19 December 2017

**SSD 7348 – Oakdale West Industrial Estate – Concept Proposal and Stage 1 Development**

WaterNSW has also reviewed the EIS and associated documents and provides the following comments specific to this development:

BRIDGE ELEVATION AND TYPICAL SECTION

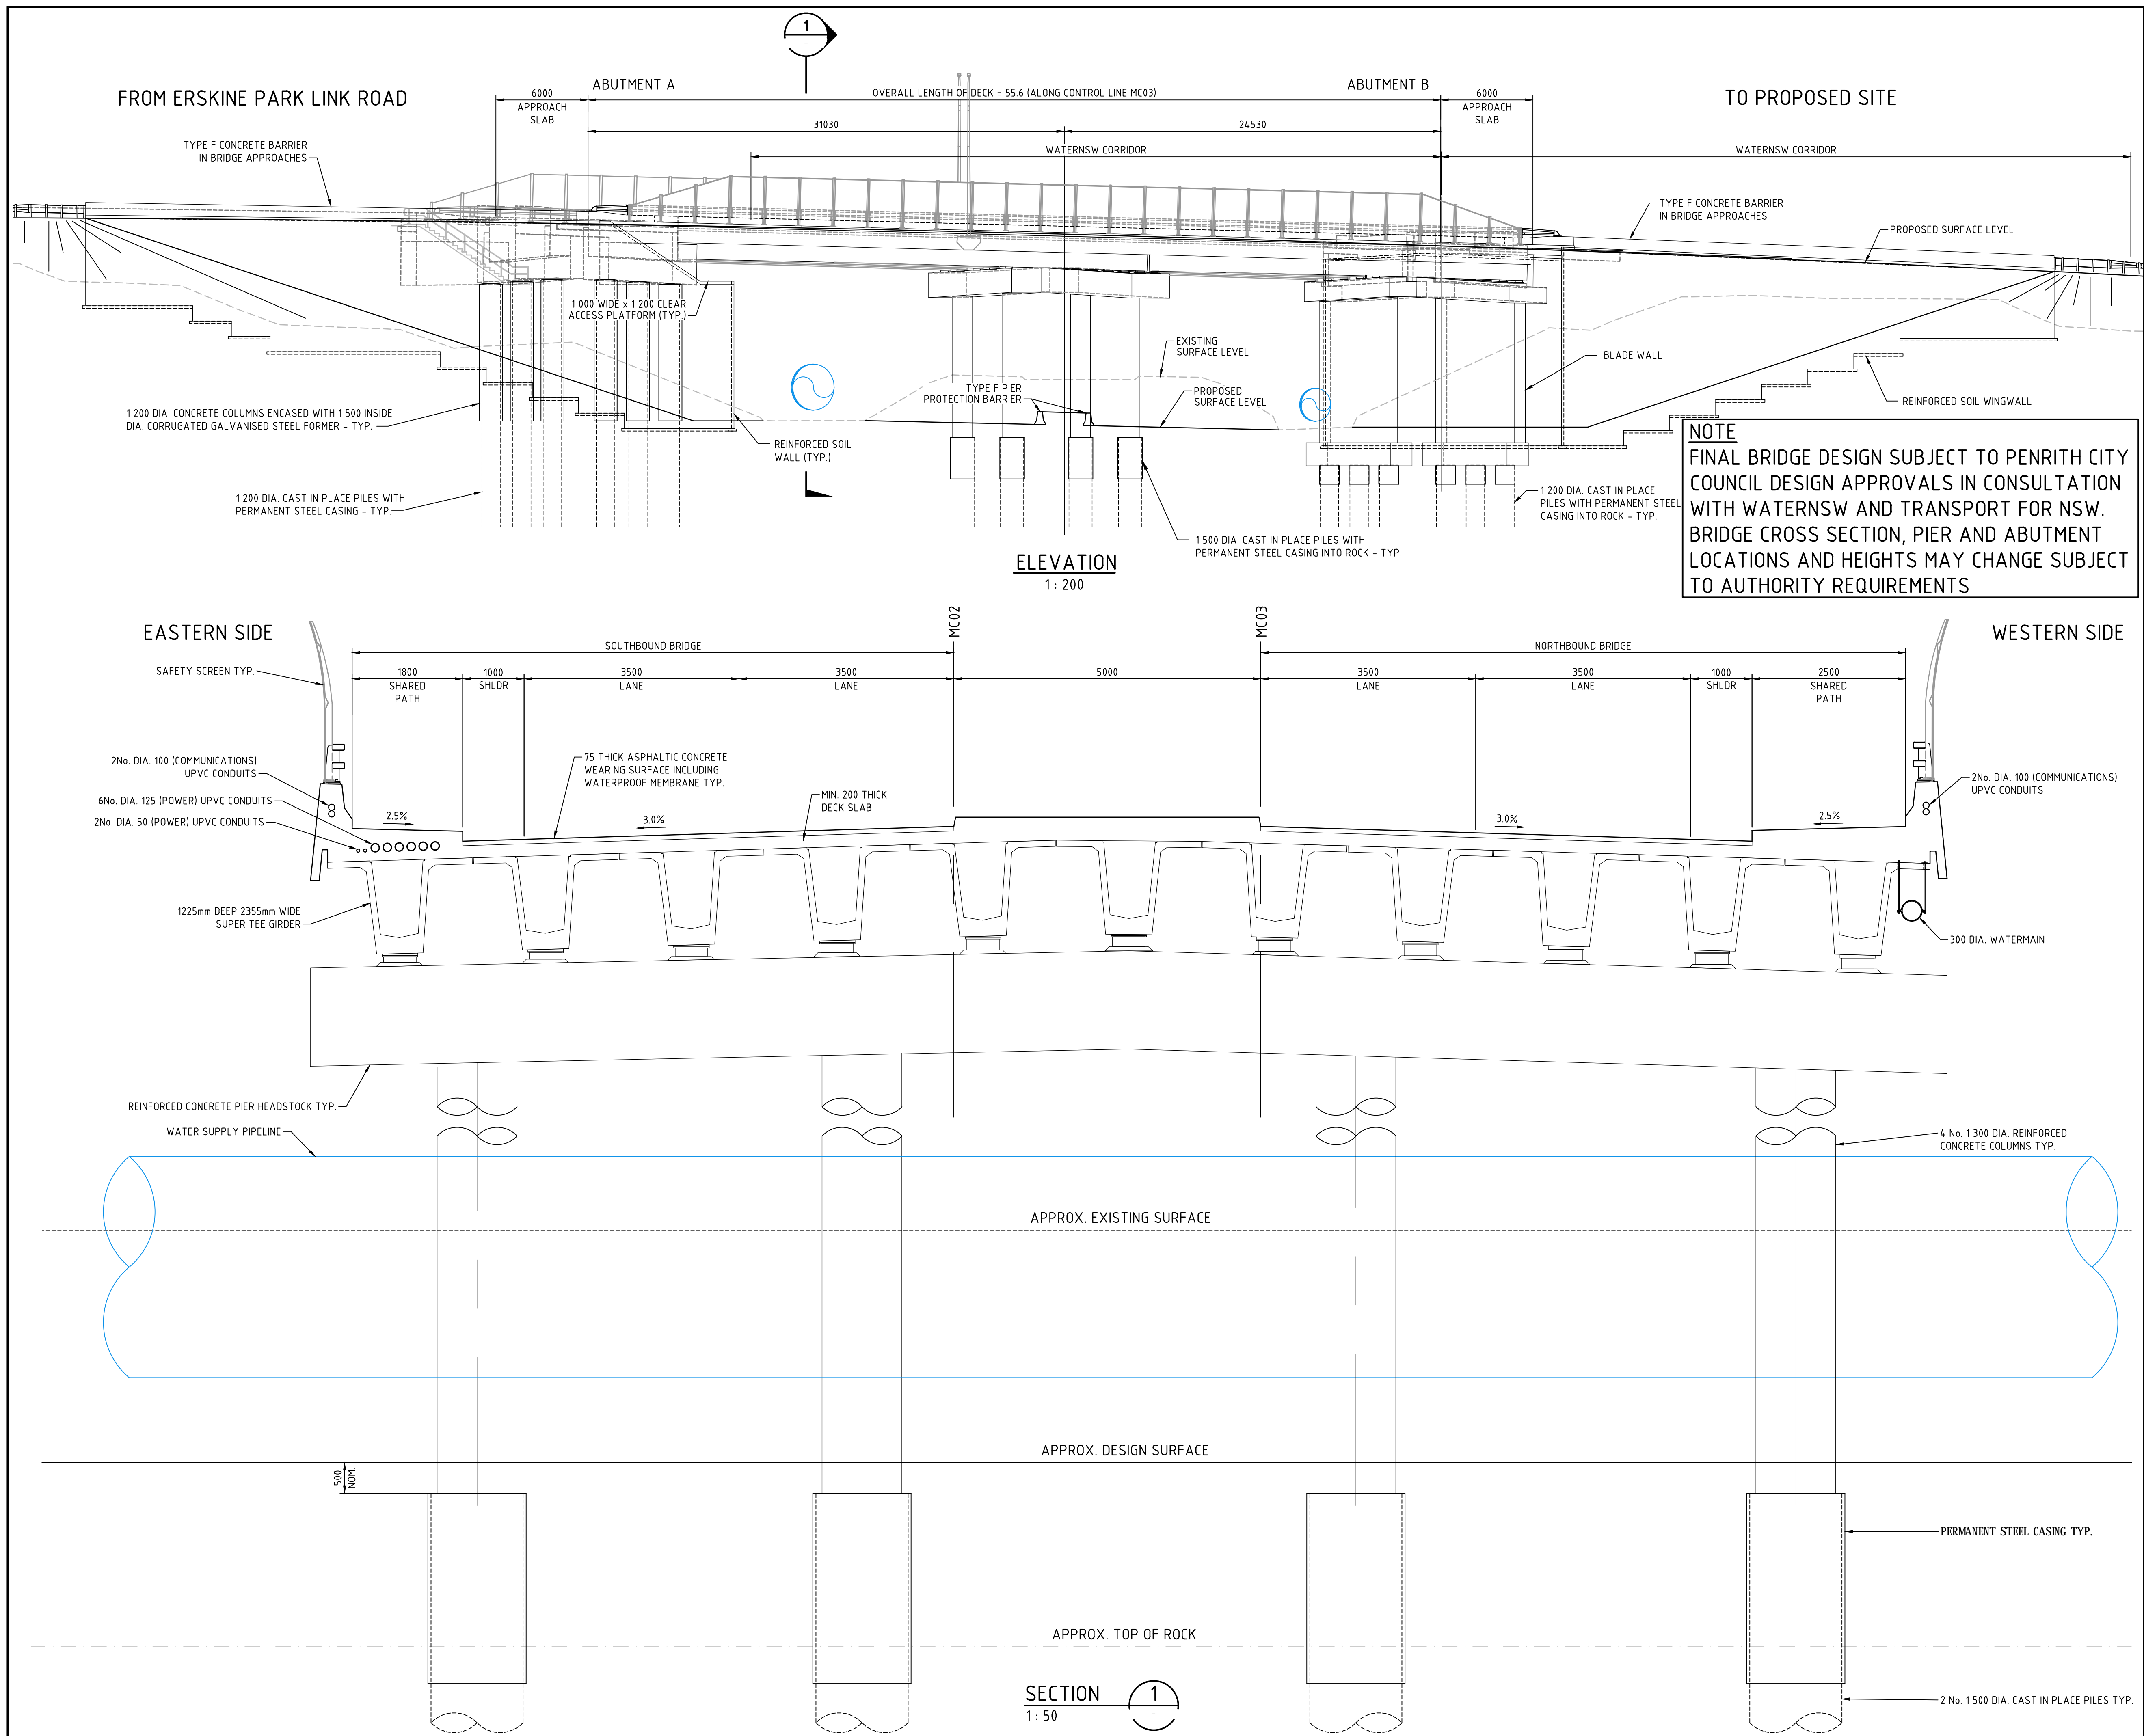
WaterNSW has reviewed the detailed design plans for the WNSLR bridge over the Pipelines corridor on exhibition on the Department's Major Projects website (Bridge elevation and typical section drawing no. 15-272-C3040 dated 25/11/16). These plans are not the same as plans provided to WaterNSW in pre-lodgement meetings between WaterNSW and AT&L (Bridge Concept Design Sections SK002 dated 17/03/17). WaterNSW understands that drawings have been modified to now include:

- a) Clearance of at least 7.5m over both the large and smaller pipeline.

The depth of the Pipelines corridor cutting and accordingly the clearance under the bridge is important in order to maintain access and turn around points for large machinery. The proposed WNSLR bridge is located over the top of WaterNSW pipeline expansion joints, rocker plate sills and anchor blocks which need to be maintained using large machinery (90T road cranes, elevated work platforms to access the pipe, scaffolding for pipe removal, heavy machinery for earthworks, etc.).

- b) A 15m span between bridge support pillars where they straddle the WaterNSW central access road.

The bridge support pillars will be on both north and south sides of the central access track within the corridor. The span between pillars must be sufficient in order to maintain access and turn around points for large machinery.

- c) High performance barrier guard rails on both sides of the bridge and concrete barriers on the approaches.

Concrete barriers and barrier guard rails installed along both sides of the bridge must be high performance rated, sufficient to re-strain B-Double size vehicles.

- d) Cranked throw screens.

Cranked throw screens installed along both sides of the bridge are required to reduce potential for trespass, malicious damage and rubbish dumping.

- e) Encased service pipelines with isolation valves on either side of the bridge.

Encasing pipes should protect all pipelines conveying high voltage cables, pressure pipelines and pipelines carrying combustible liquids and flammable fluids. Isolating valves should be installed on the stormwater pipes at either side of the WaterNSW boundary to facilitate the isolation of these pipes in the event that WaterNSW has to undertake significant work within the corridor.

- f) No impact to the earthen embankments within the Pipelines corridor.

The pipelines in the vicinity of the bridge are well protected by earthen embankments which must not be impacted by the bulk earthworks required for bridge construction. There is no requirement from WaterNSW for northern and southern access tracks under the bridge.

- g) No access into the Pipelines corridor.

Access into the Pipelines corridor is provided in the west at Mamre Rd and in the east at Old Wallgrove Rd. These access points provide safe, wide and deep laybacks and allow for large vehicles such as cranes and trucks to safely stop at the gate and access the Pipelines corridor. No access into the Pipelines corridor will be provided at the WNSLR bridge crossing.

- *WaterNSW shall be consulted on the final WNSLR bridge design details eight (8) weeks prior to works commencing, to allow for checking of design and related works procedures and revisions as required.*

*The WNSLR bridge design will include but is not limited to: Clearance of at least 7.5m over both the large and smaller pipeline; a 15m span between bridge support pillars where they straddle the WaterNSW central access road; high performance concrete barrier/guard rails on both sides of bridge and its approaches; and cranked throw screens.*

Title
STORMWATER DRAINAGE CATCHMENT PLAN (PRE-DEVELOPED)

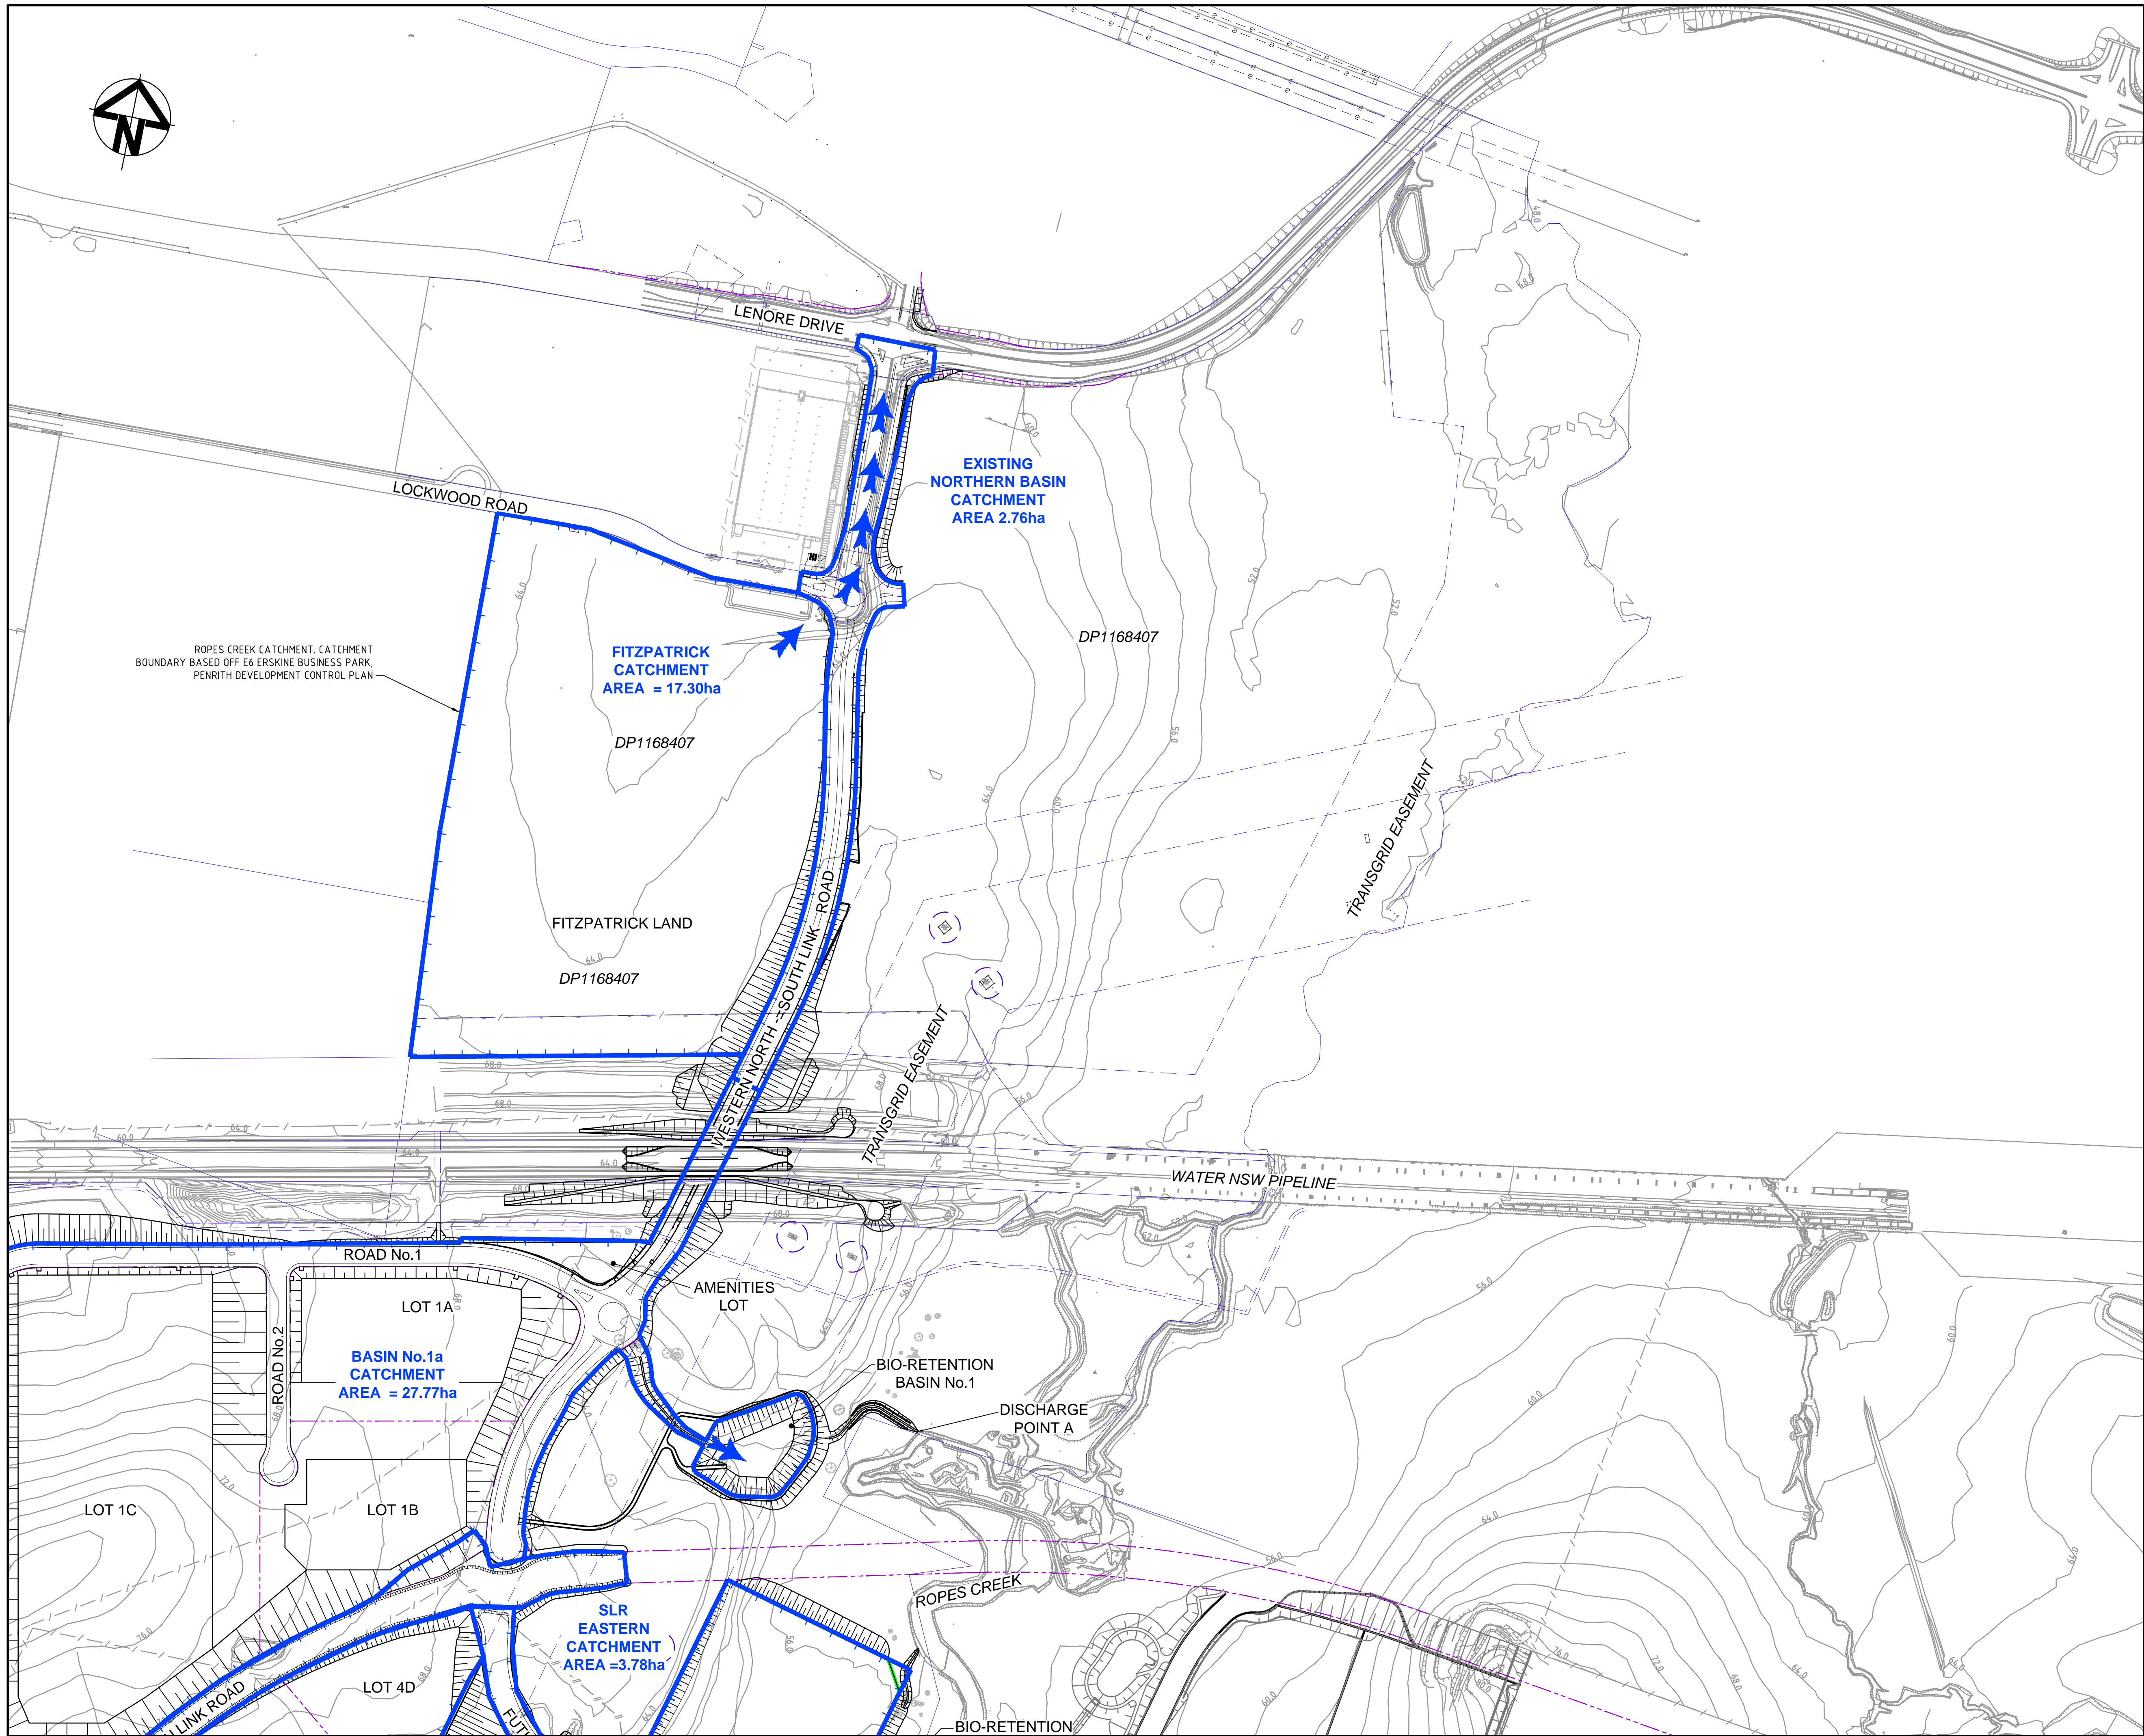
WaterNSW notes that the final discharge of treated stormwater will follow through the existing stormwater cycle into Ropes Creek or other local swales and waterways around the Site (Urban Design Report p53). The Stormwater Drainage Catchment Plan shows discharge point A into Ropes Creek and discharge point B into a local swale, both flowing across the Pipelines corridor. However, there is also a further discharge point coming from the large dam on the northern boundary of the development site into the Pipelines corridor near the valve house (the brick structure at the low point of the pipeline) which continues into a tributary of South Creek on the northern boundary of the corridor.

Development drawings currently show that bio-retention basin 1 (which replaces the large dam) will drain towards bio-retention basin 2 and together they will discharge at point B, across the Pipelines corridor, avoiding the valve house discharge point. The combined flow at this point, must not exceed the culvert's capacity.

Changes in drainage and stormwater may increase flooding, subsidence and erosion. WaterNSW requests that stormwater drainage be designed to comply with the requirement that post development peak stormwater flows are no greater than pre-development peak stormwater flows. The development, including all earthworks, dewatering of the existing dam and changes in levels and impervious areas due to the development, must not cause the stormwater flows into the Pipelines corridor to increase above their current levels.

- *No peak stormwater flows exceeding the existing levels shall enter WaterNSW drainage lines or the Pipelines corridor from the development site.*
